From: Sue Howell
Sent: 30 March 2017 12:26
To: Planning.Responses
Cc: David Innes
Subject: RE: Planning Consultation on: Y/5/17/OUT

Comments from Greenspace

APPLICATION Y/5/17/OUT

Description of Works: Outline application for 51no. dwellings with all matters reserved except for access. This application is a Departure from the Development Plan.

Tree protection plan

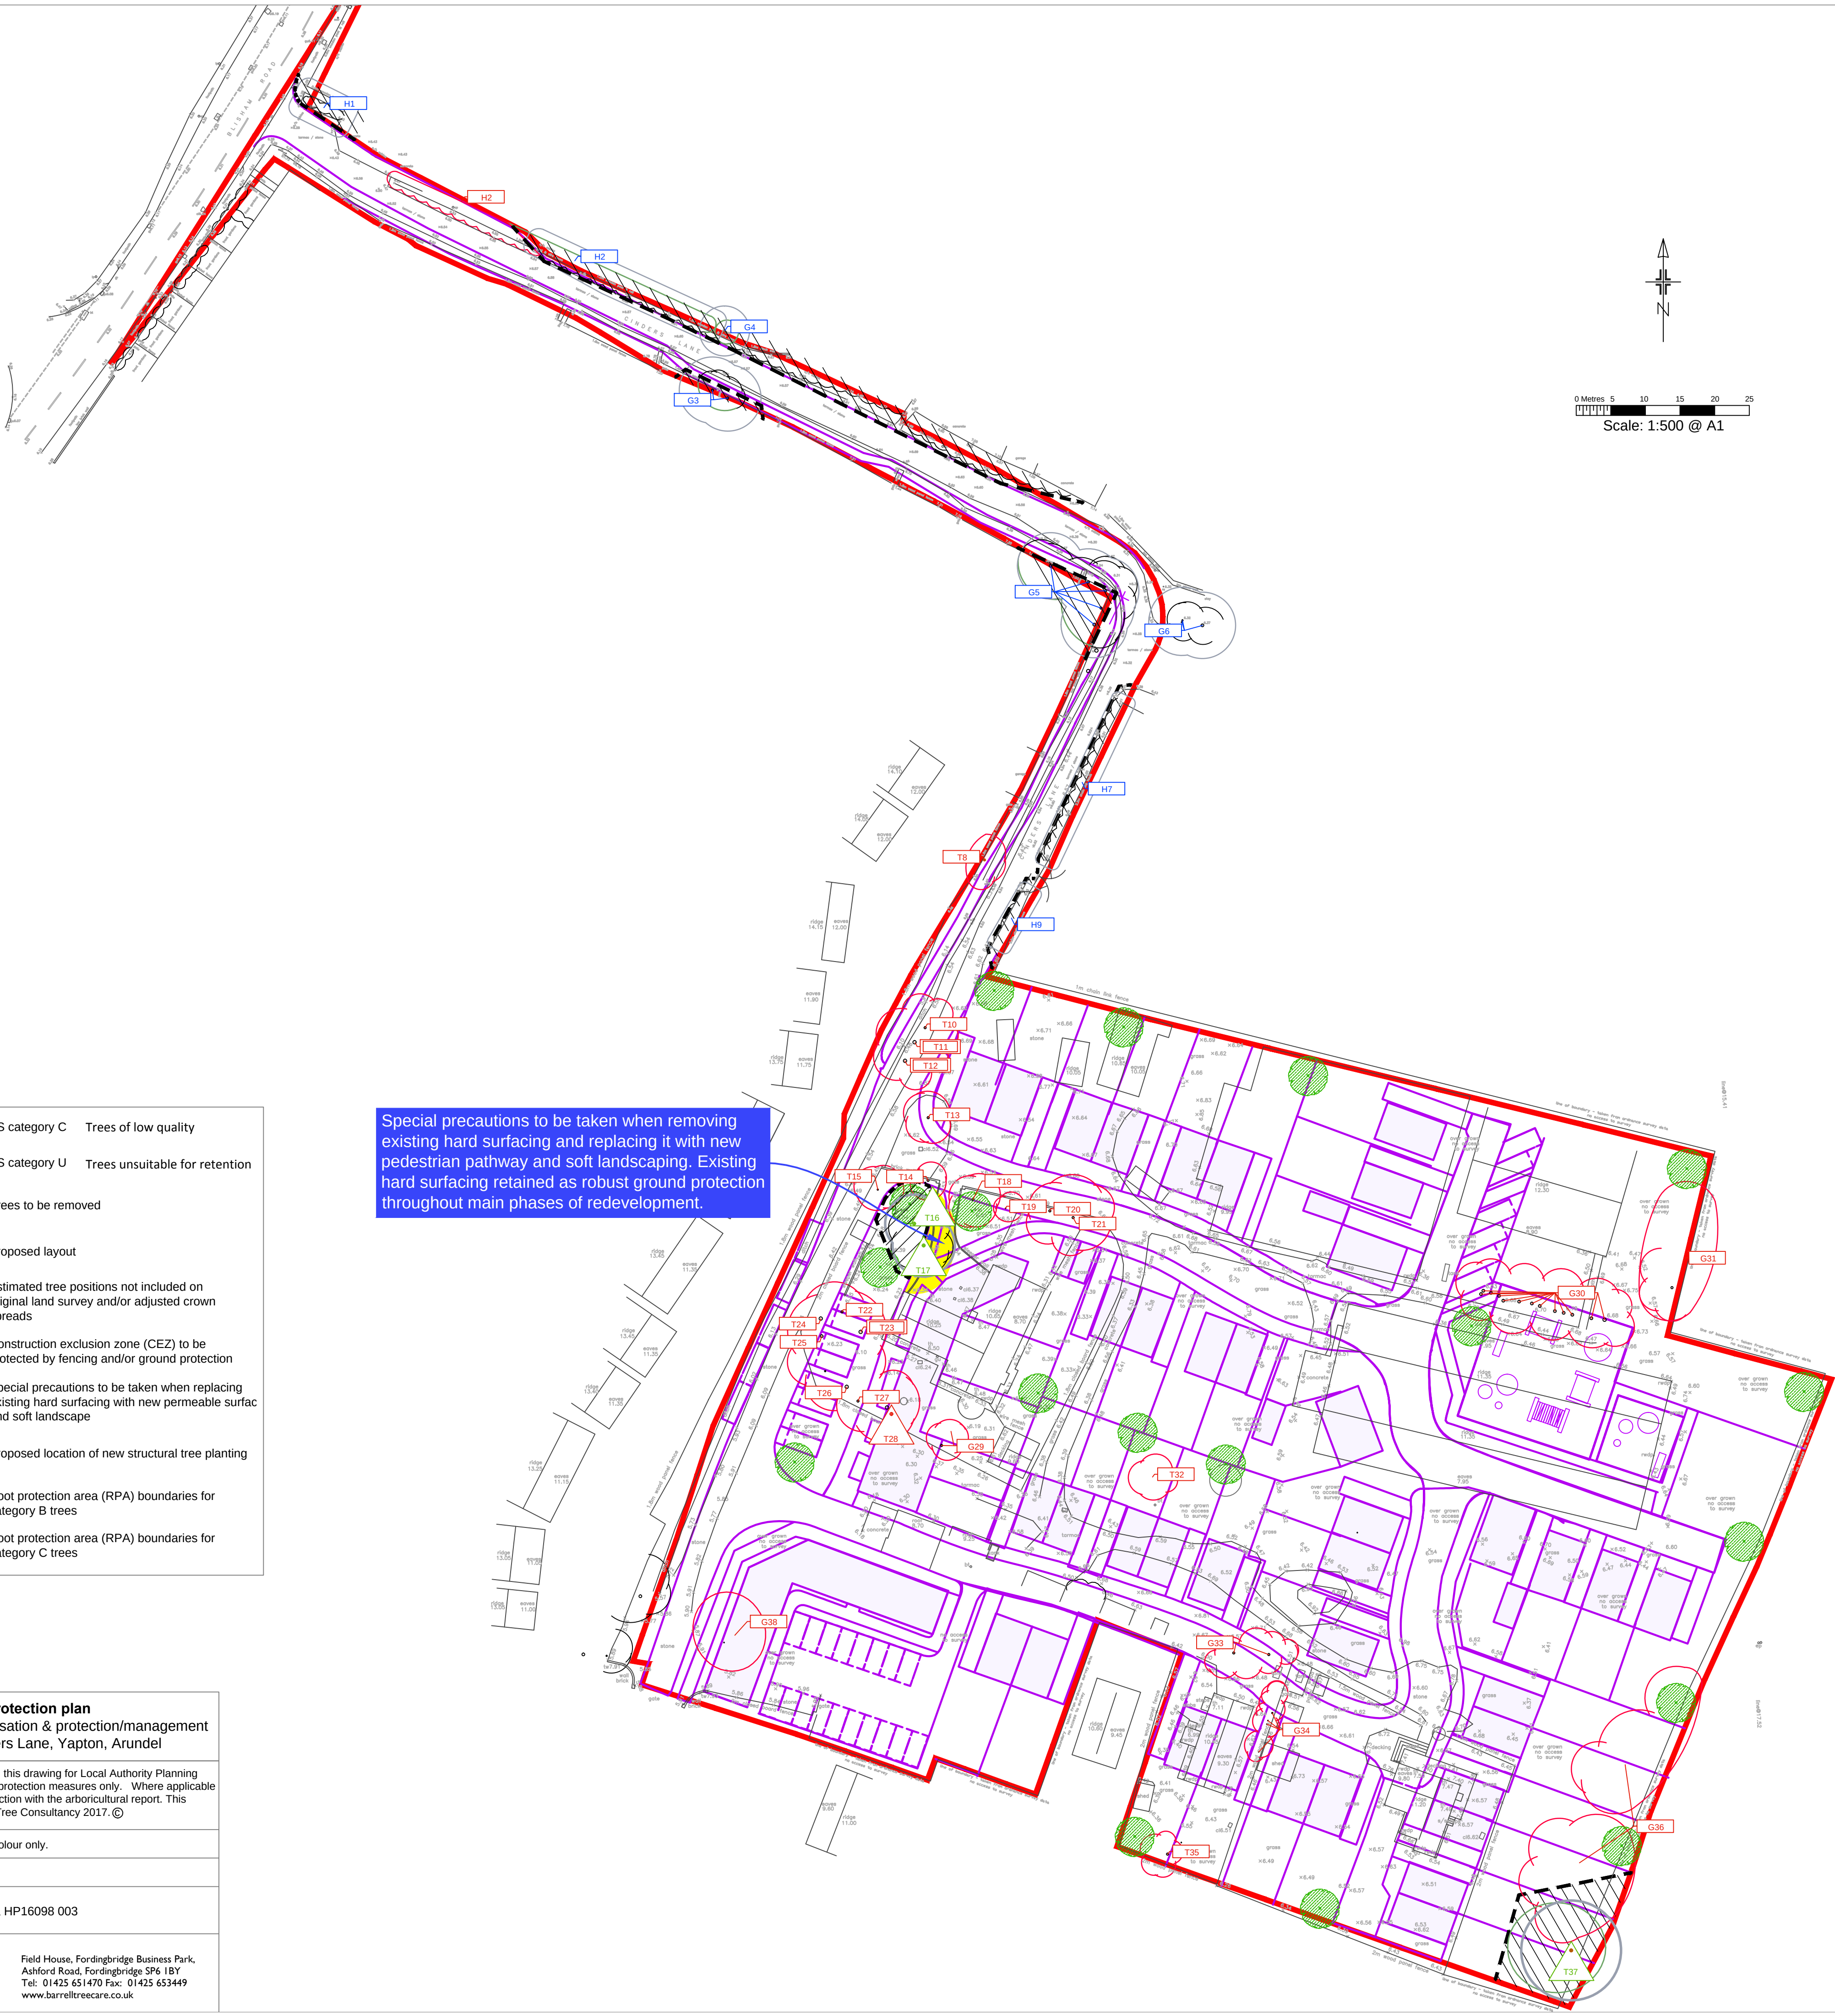
A tree survey relating to existing trees has been undertaken. Tree protection fencing requirements have been identified and the tree protection plan submitted which would need to be conditioned with any permission.

Any significant existing trees particularly along the boundary edge must be protected during the works if they are identified to provide good visual amenity in addition to their biodiversity importance. Any trees that have the potential for a long life expectancy, with potential to become a prominent feature within the landscape and are worthy of protection, with adequate fencing according to the BS5837 (2012) Provision for fencing according to each of the trees' correct and calculated root protection area must be erected prior to the commencement of any development activities.

Any trees or vegetation that fall within the proposed or periphery of the development, may provide significant aesthetic impact to the location. Any trees in particular along the boundaries, which adjoin neighbouring land could provide potential valuable screening and should be retained particularly those adjoining the settlement boundary. Any considered tree removal from this site should be agreed with Arun District Councils Tree Officer. Root protection Areas (RPA) should extend into the development site and to those in neighbouring land. Before construction, a tree protection scheme must be in place for any retained trees including trees whose root protection areas fall within the construction zone from neighbouring land. This should be in accordance with BS 5837:2012 'Trees in relation to construction' Any agreed removed trees should be mitigated for allowing for inclusion of native species for biodiversity purposes and fitting to the semi-rural setting.

Vegetation where detailed for retention to boundaries to be retained – this is noted as recommended under tree protection.
